Metro Martin Place

Sydney Metro and Over Station Development Design Review Panels

DRP #06

7 August 2018

Updated proposal - S/E and S/W focus - Potential Zero Tower Setback

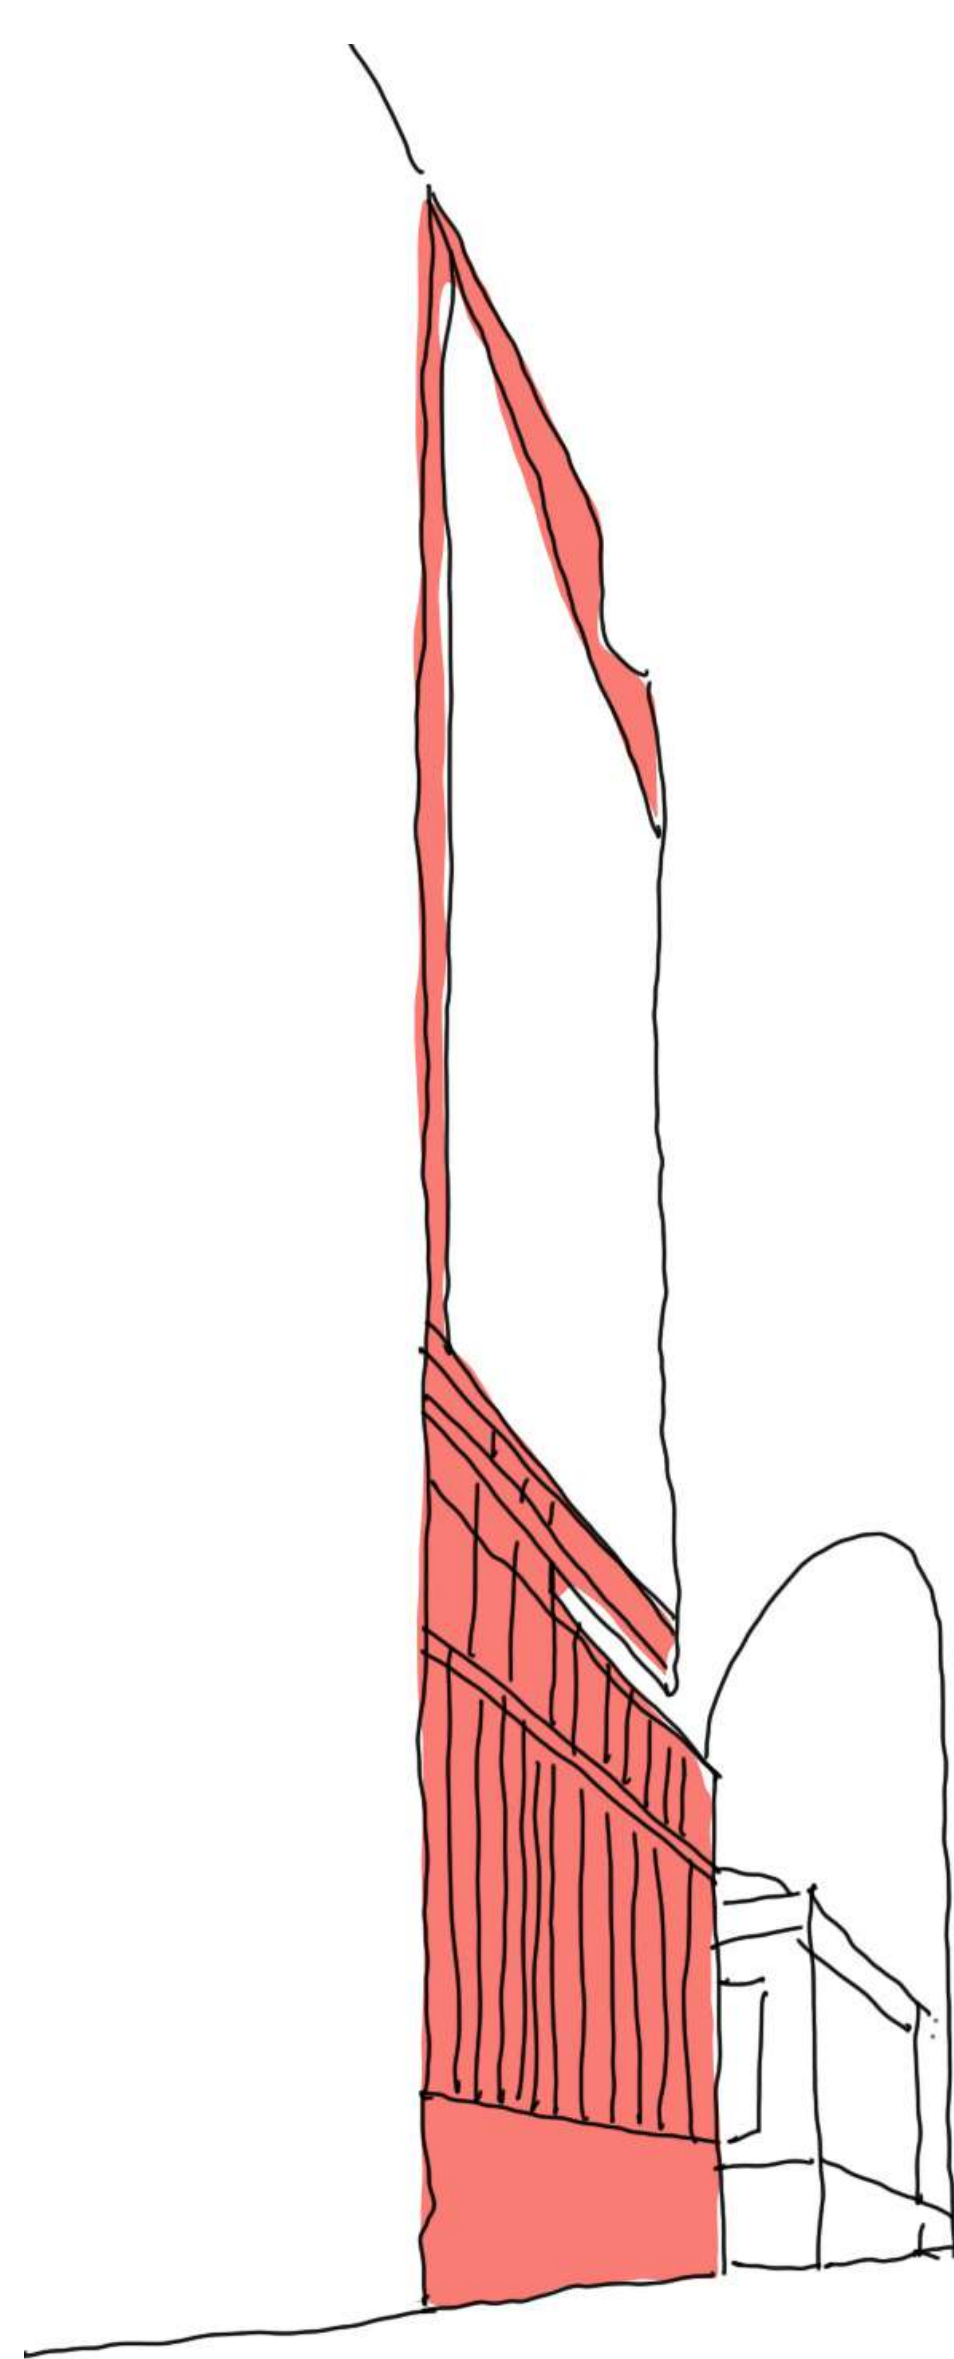
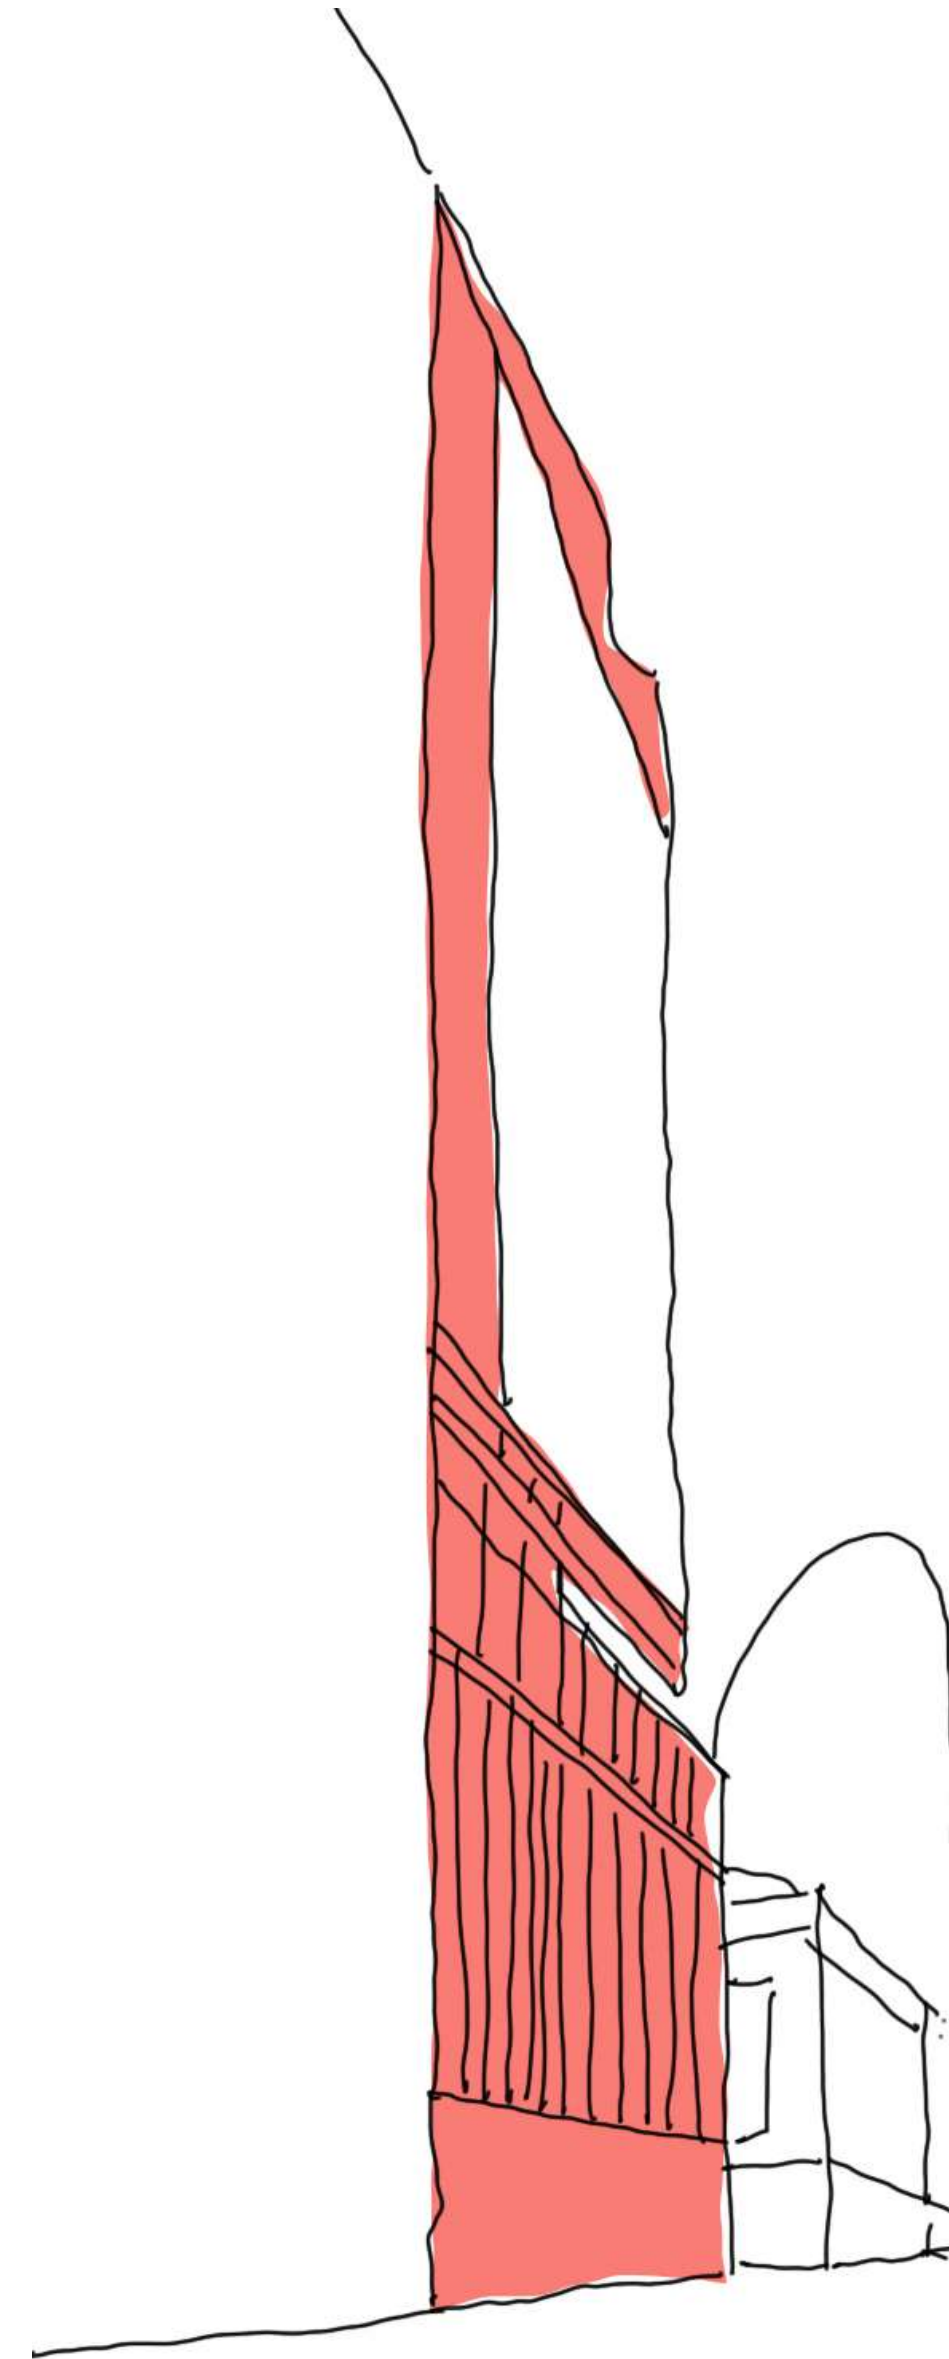
The OSD DRP has indicated the intent of the setbacks above the podium has not been met by the tower and has recommended increasing the setbacks at the south east and south west corners '*to improve architectural expression and urban design outcomes for the block*'.

- the intent of the setback above the podium has not been met by the tower, which extends the full height and width of the approved envelope and is likely to result in a poor urban design outcome for the southern end of the street block and adjacent development
- we recommend increasing the setbacks at the south east and south west corners of the tower to improve architectural expression and urban design outcomes for the block.’

Tzannes presentation, provided under separate cover, responds to the OSD DRP's feedback.

**SYDNEY METRO - MARTIN PLACE
LEVEL 10 PLAN
GENERAL ARRANGEMENT**

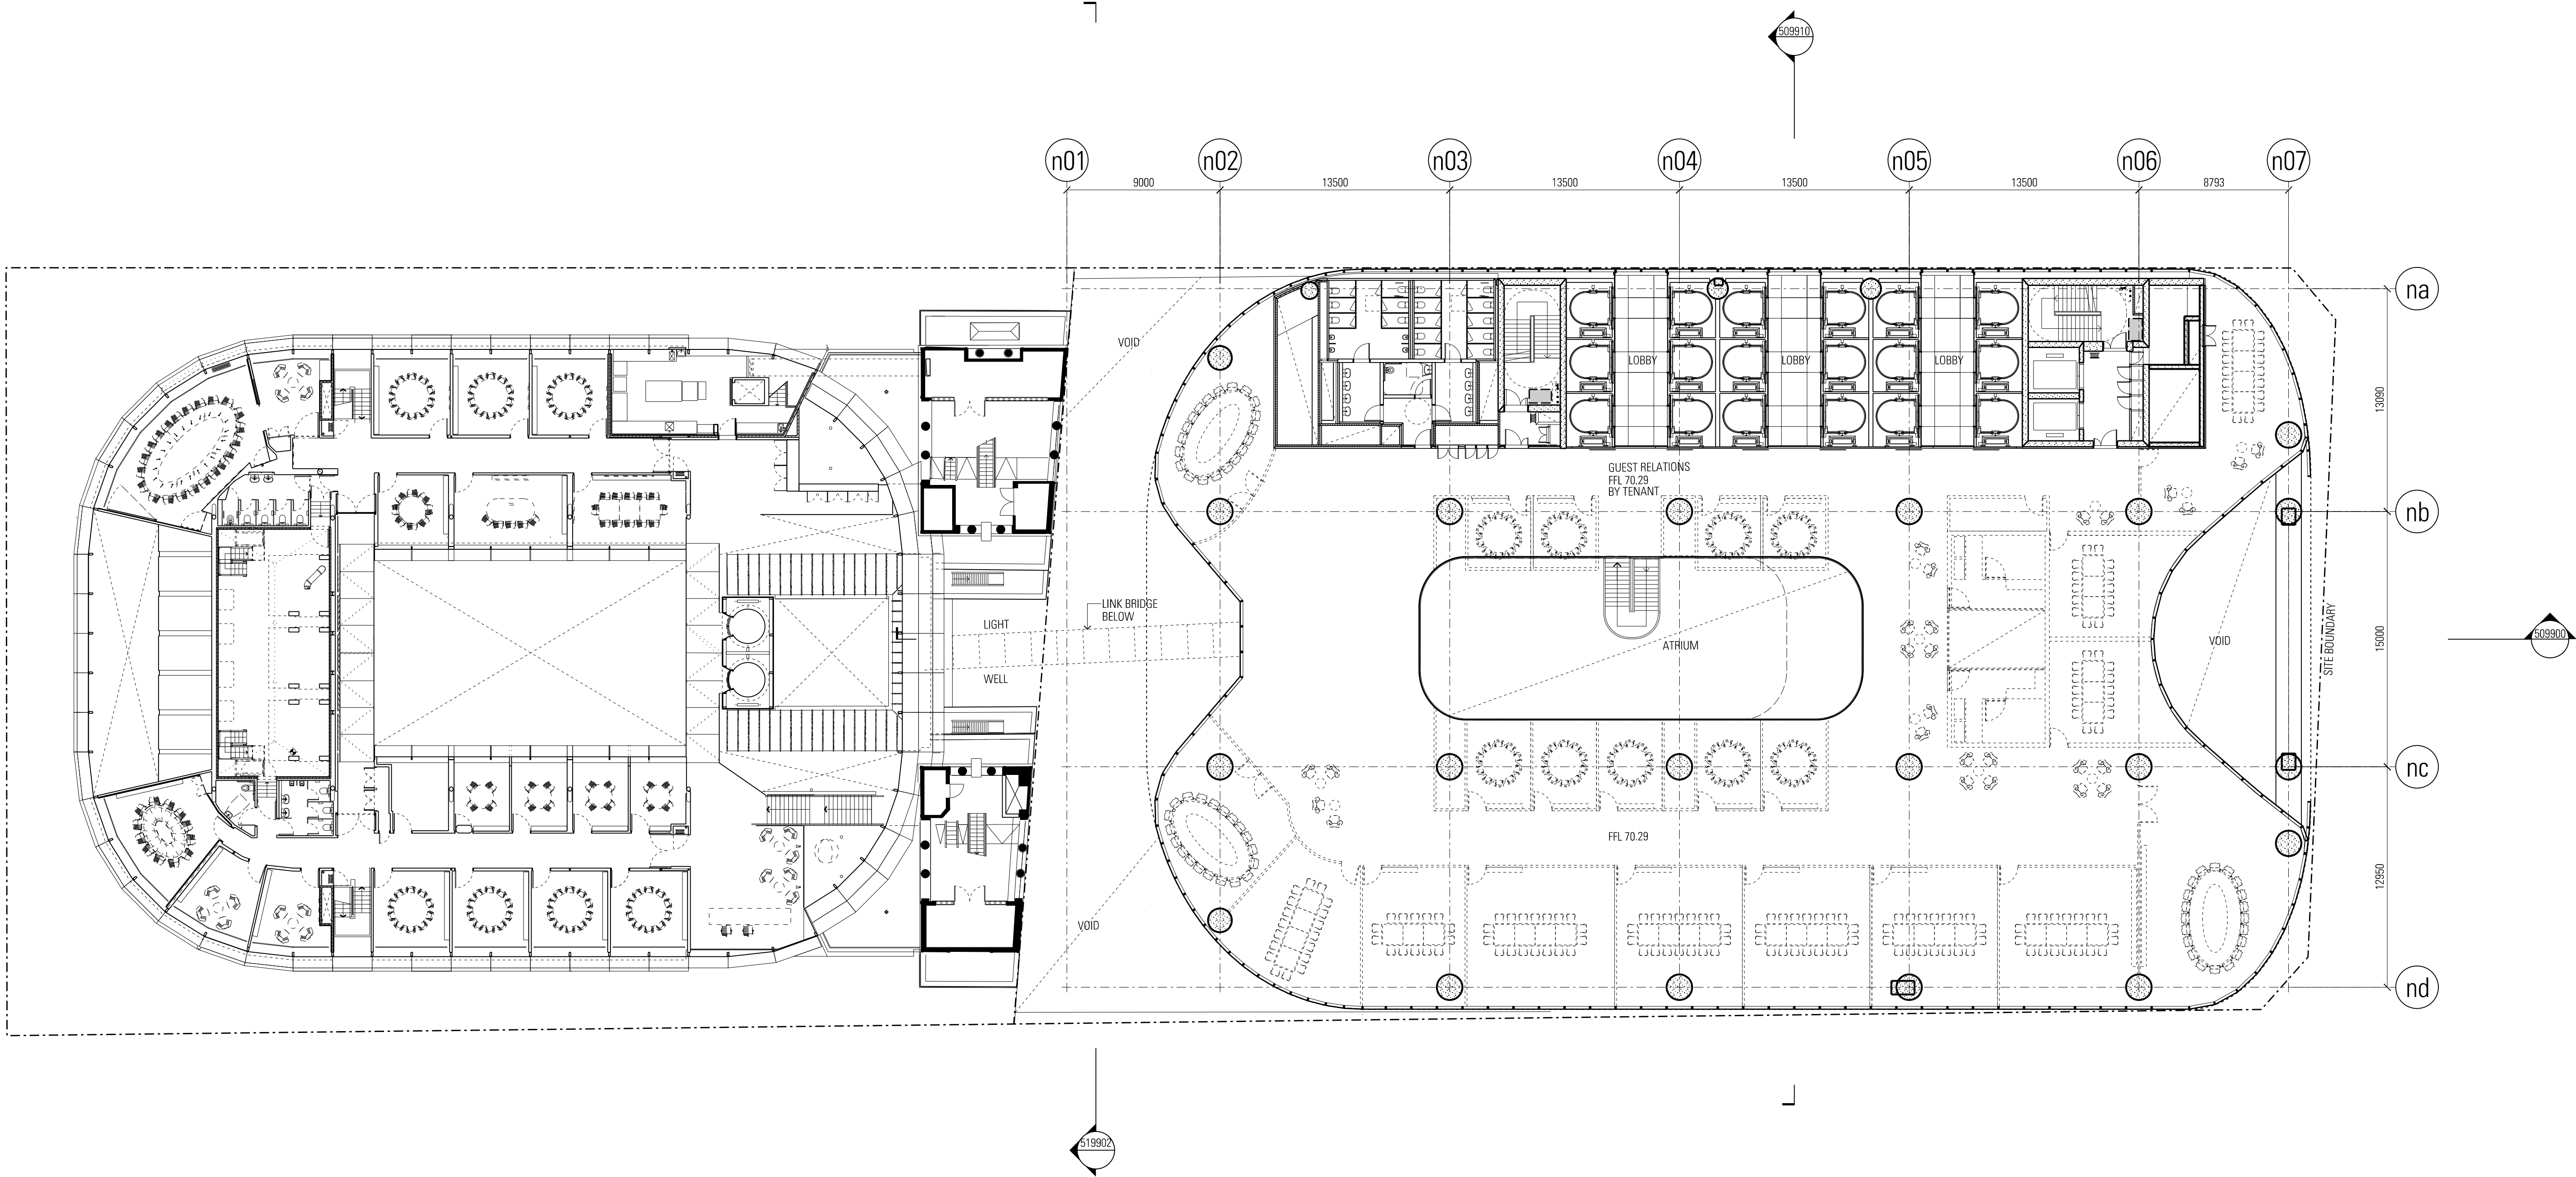
The OSD DRP has recommended reconsideration of the Level 10 terrace and requested more details on materials.

- revised Level 10 terrace depth
- shading elements on tower and particularly southern façade
- proposed materials for each component of the tower

JPW presentation, presented under separate cover, responds to the OSD DRP's advice and recommendations regarding the North Tower's architectural expression, including:
